**From:** Anita Gardner  
**Sent:** 01 May 2019 16:35  
**To:** Nicola Moore  
**Subject:** FW: Littlehampton Swimming & Sports Centre: Non-material amendment  
**Attachments:** E531-M&R-V4-00-DR-E-0631.pdf

Dear Anita, please find attached the documents for the non-material amendment associated with the new Littlehampton Leisure Centre application ref. LU/314/16/PL.

The proposed changes outlined in my letter attached are for amendments to the car park markings and a small reduction in the number of spaces provided, a service route to the adjacent golf course for the parks department and a light pole to ensure safe use of said route.

DRAWING
GA Site Plan

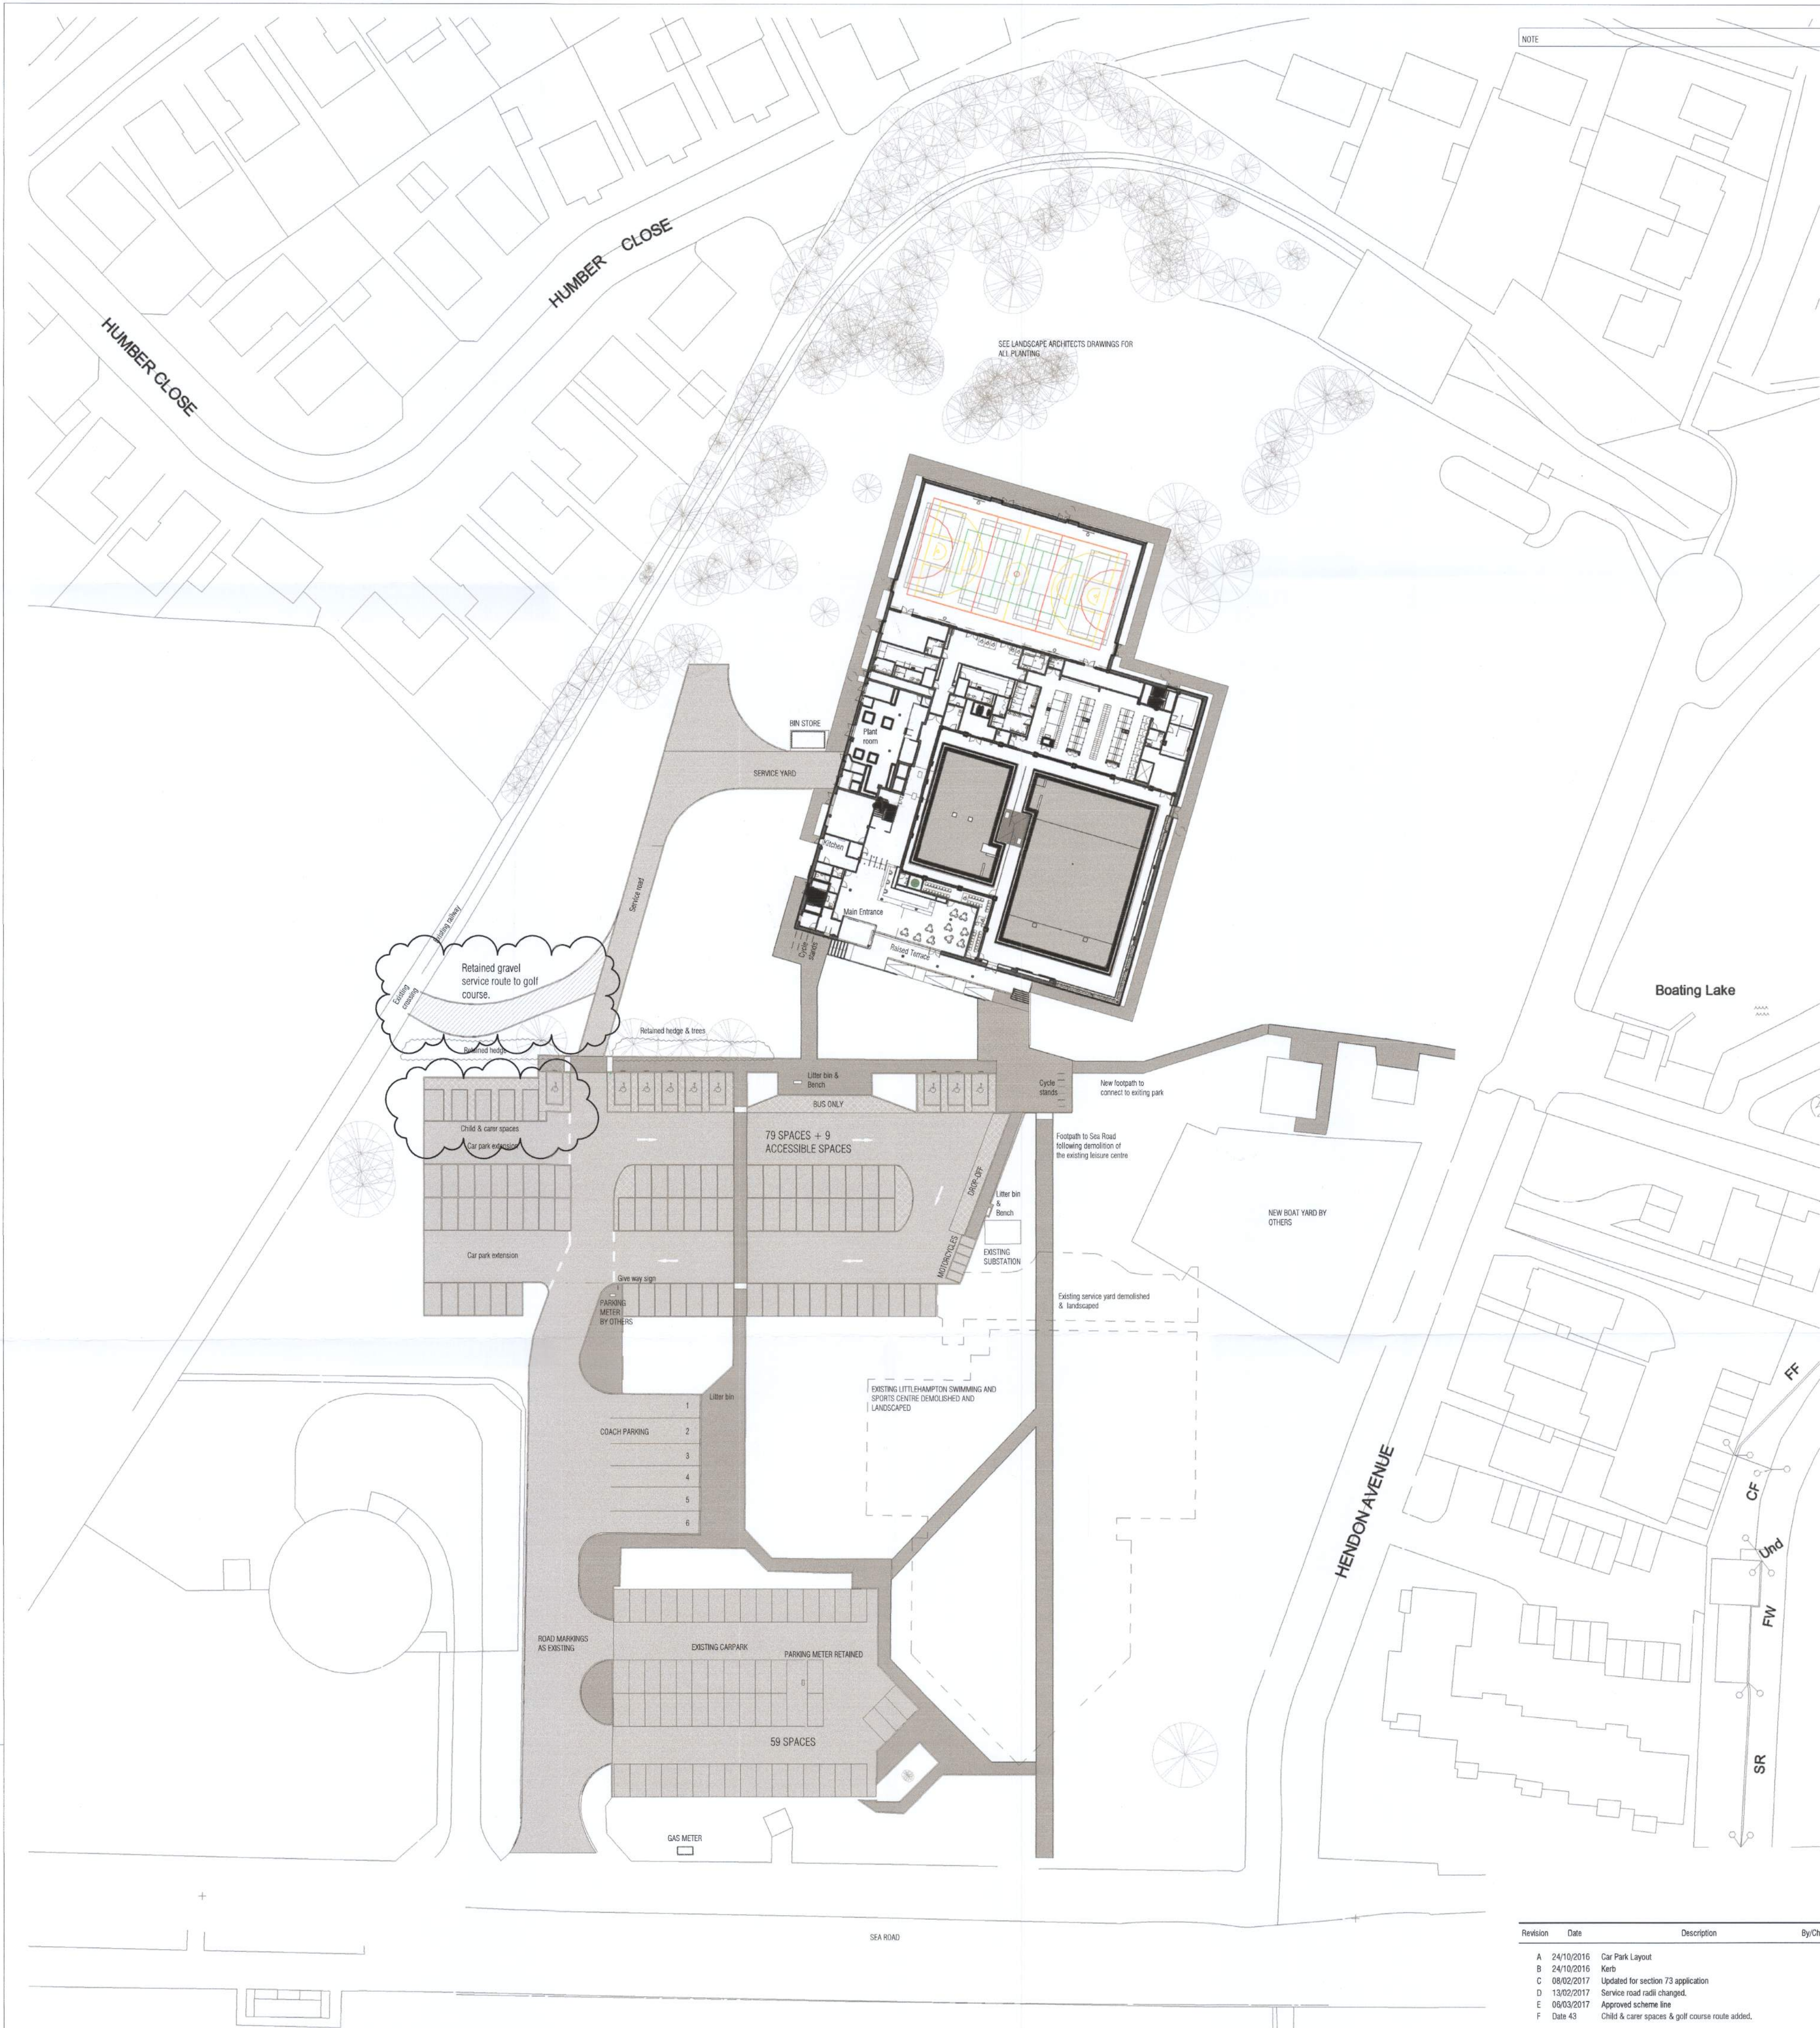
It maybe the removal of lighting columns. I have seen an e-mail from Rachel confirming that she didn't need the service route lit so the columns should be removed from the plan. Has this been done?

Just to confirm this is now the correct plan – the lighting column has been removed from the golf course access road. The columns on the service road to the building are as required.
